From: Chris Moore [REDACTED]
Sent: 31 March 2025 11:53
To: Hannah Kersley <Hannah.Kersley@arun.gov.uk>
[REDACTED]
Subject: RE: AL/13/25/DOC

I have just been reviewing the details submitted for conditions 8 and 9.

FRONT (NORTH) ELEVATION

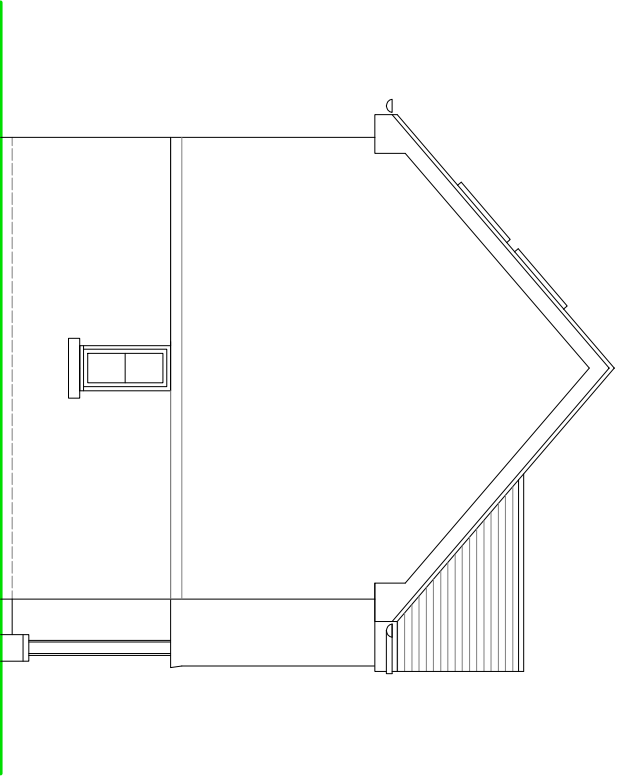
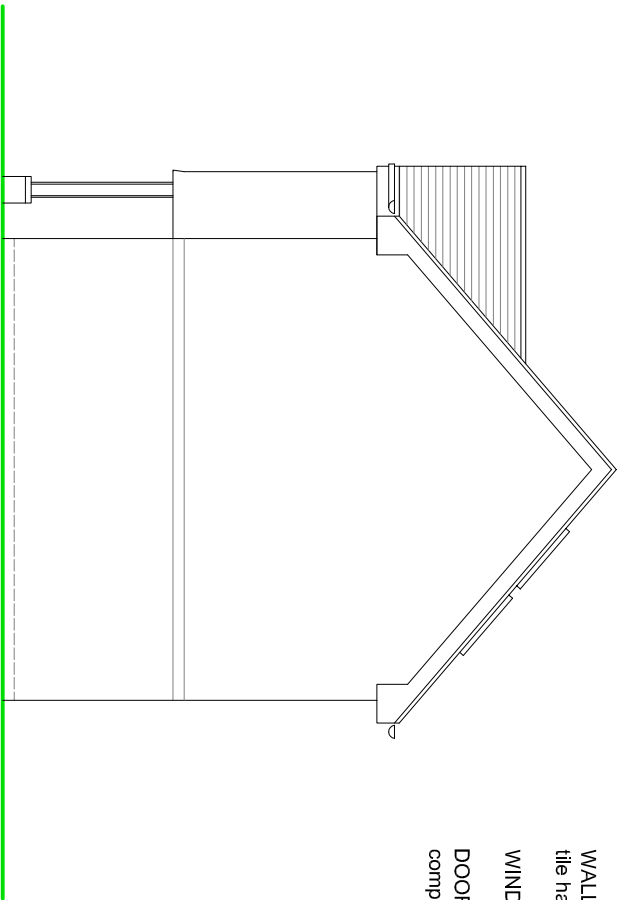
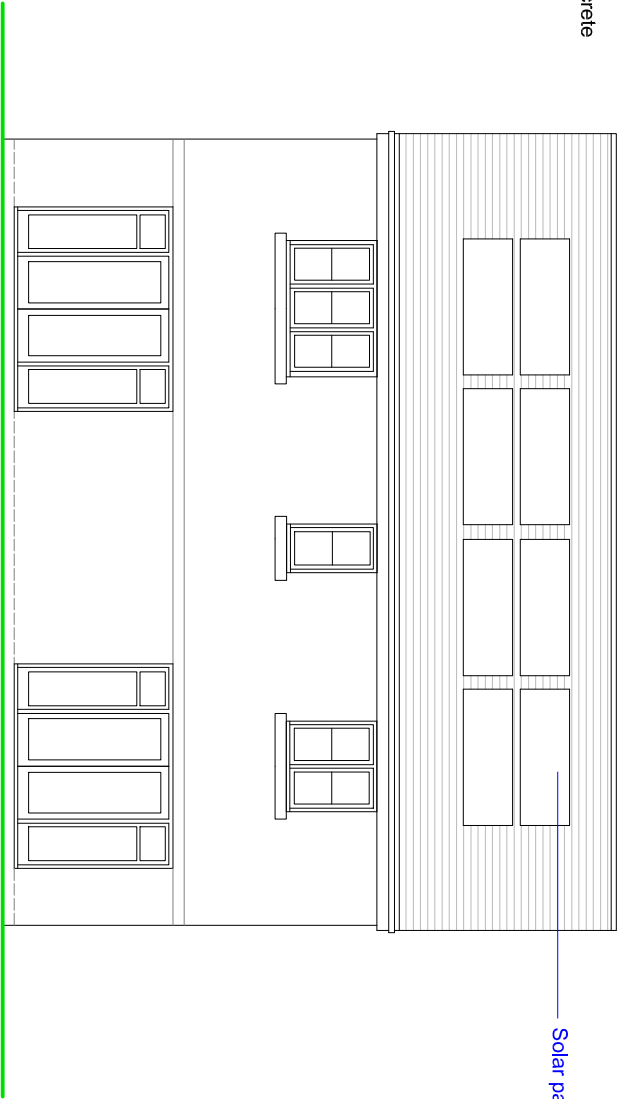
In terms of Condition 8, we are happy with the details submitted so far, although note there appear to be no details of the colour / material of the windows and doors to be used – please could we have this information clarified?

WINDOWS - Anthracite PVC framed double glazed units.

DOORS - Anthracite PVC or aluminium framed double glazed units, composite front door.

PROPOSED ROOF PLAN
(PLOT 2)

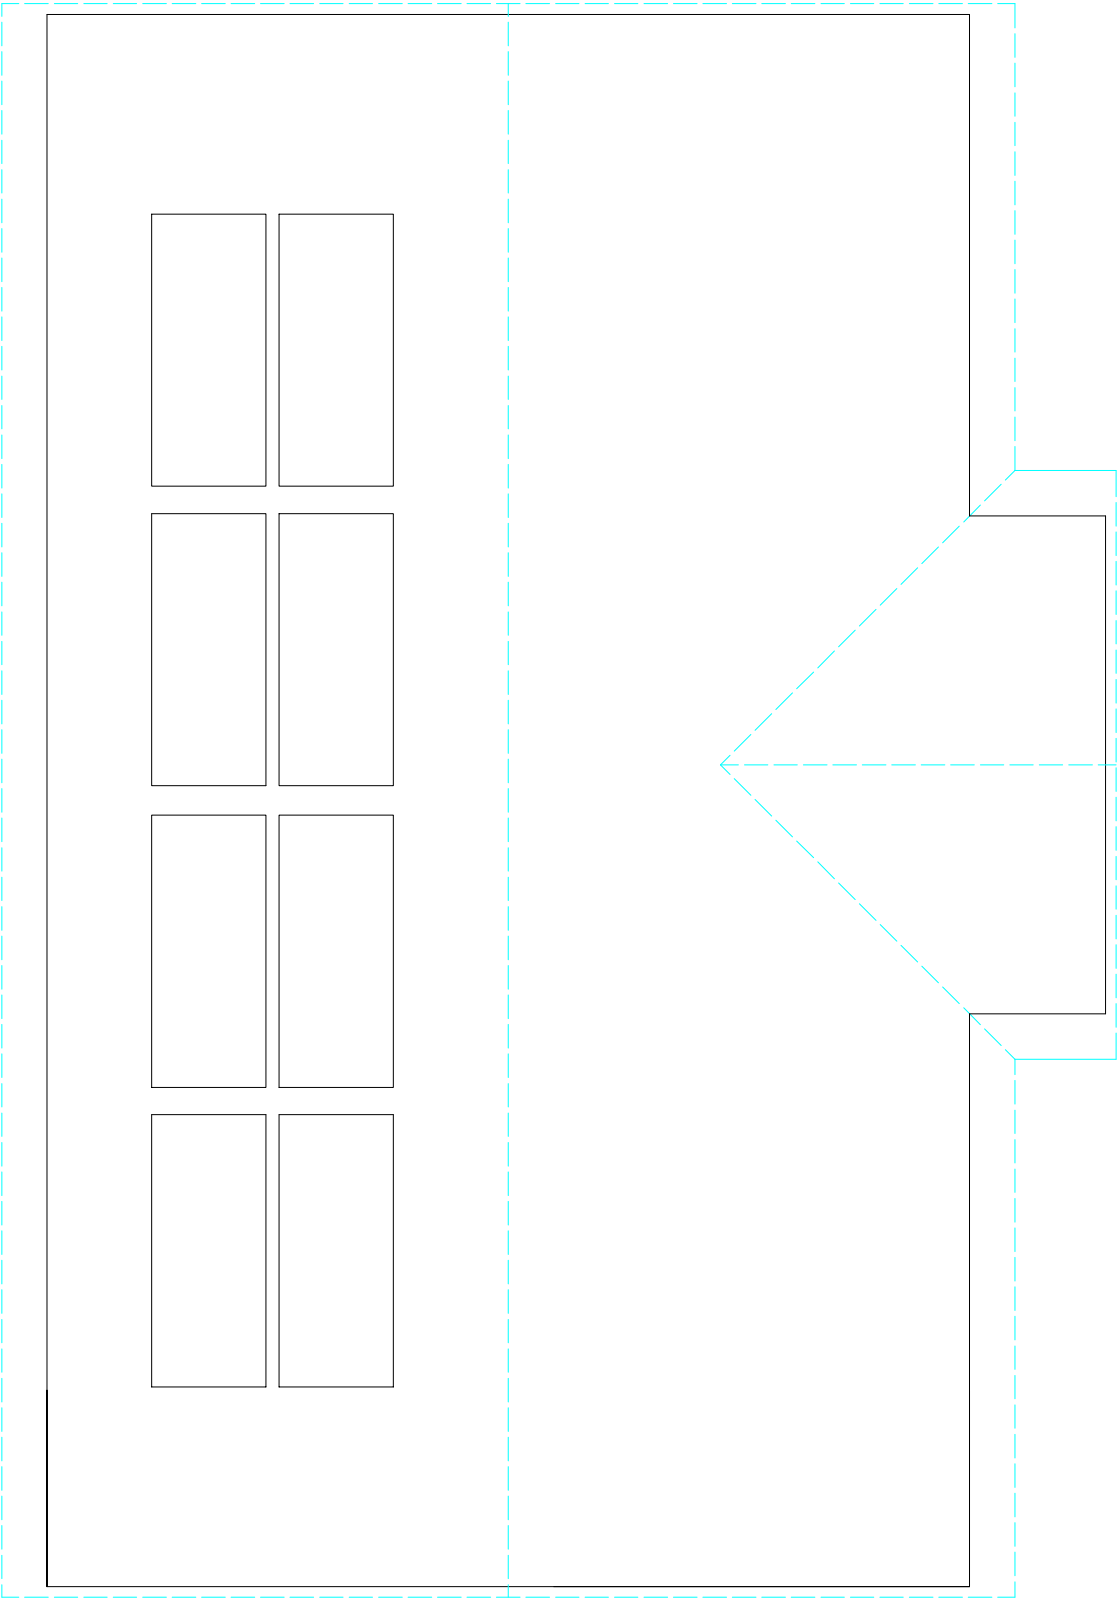
In regard to Condition 9, I'm afraid I do need to request some further information be sent over for the solar / PV panels. We will need to see the technical specifications for the model and make proposed to be used, and a plan showing how many panels are to be installed and where they will be located. We will also need calculations evidencing that the panels will generate 10% or more of the energy for the site. Unfortunately EV charging does not count towards the requirements of this condition, so it will be determined solely on the information provided in respect of the PV panels.
